Re: Permit #2212-162
Rader SFR Addition and Remodel
7310 86th Ave SE
Intake Comment Response Letter

Regarding the combined intake comments dated 1/4/23 for the remodel/addition permit application listed above, we would like to provide the following corrections and locations on the drawings where they can be found (responses are bulleted and italicized below summarized comment):

EXTERIOR ELEVATIONS

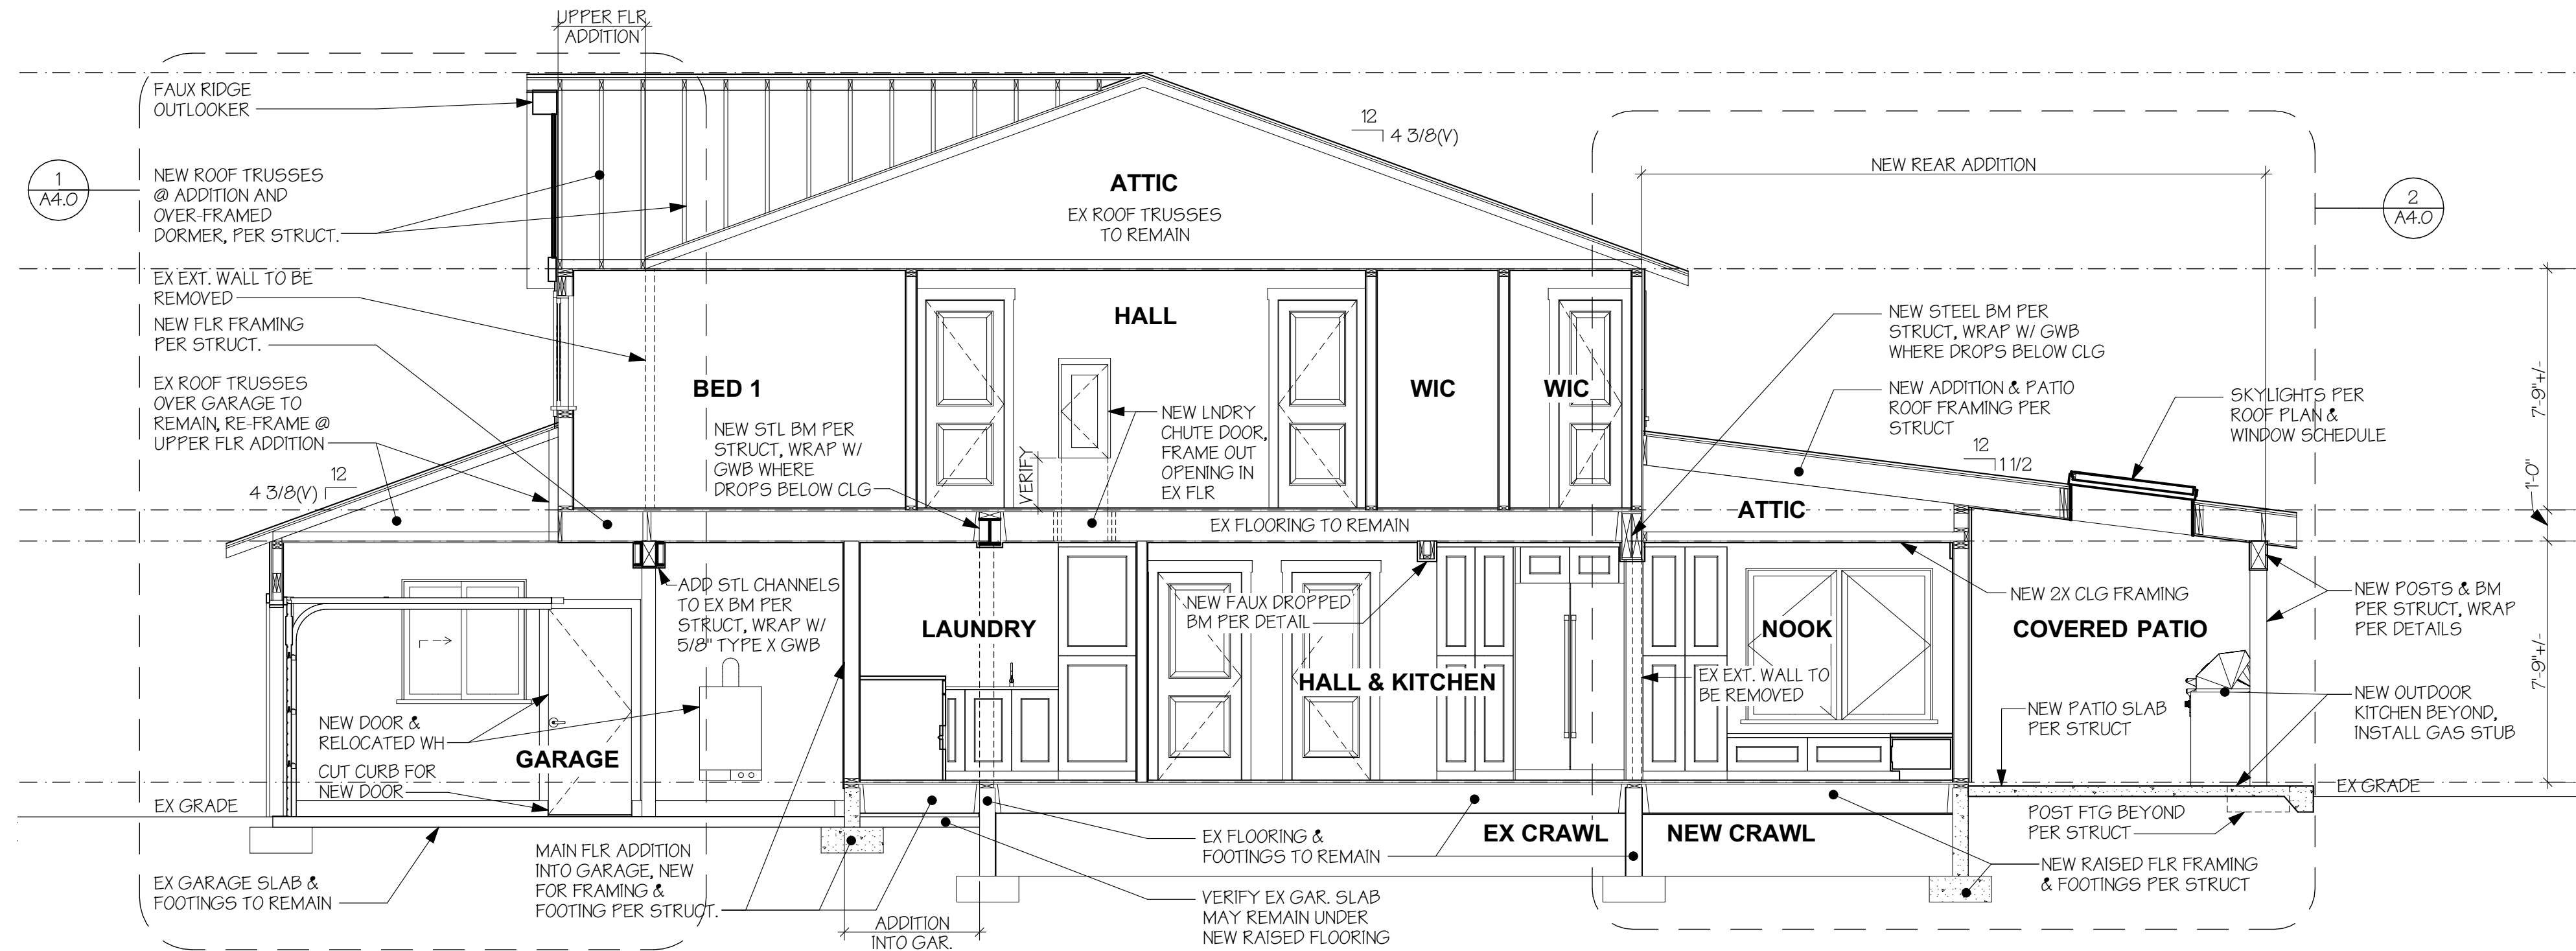
- v. *Development plan set taking into account all recommendations from geotechnical evaluation*
3. Correct side yard setbacks in compliance with MICC 19.02.020(C)(1)(c)(iii).

- *For clarity, additional roof-height dimensions above finished grade have been added to West (front) and East building elevations, see sheets A2.0 and A2.1. We believe side yards have been identified correctly on the site plan (sheet 02). At the minimum side setback of the property (south side), the existing gabled roof end adjacent to the side yard does not exceed 18'-0" above finished grade, so the minimum side yard dimension would be 5'-0" per sec. (C)(1)(c)(ii), or 33% of the aggregate total width, which for this lot is 15'-0" (90'-0" or less lot width). The remaining side yard dimension on the north would be 10'-0" (which allows a ridge ht. of 25'-0" or more; although the max ridge height here does not exceed 25'-0"). Neither the existing nor proposed building footprint encroaches into either side yard.*
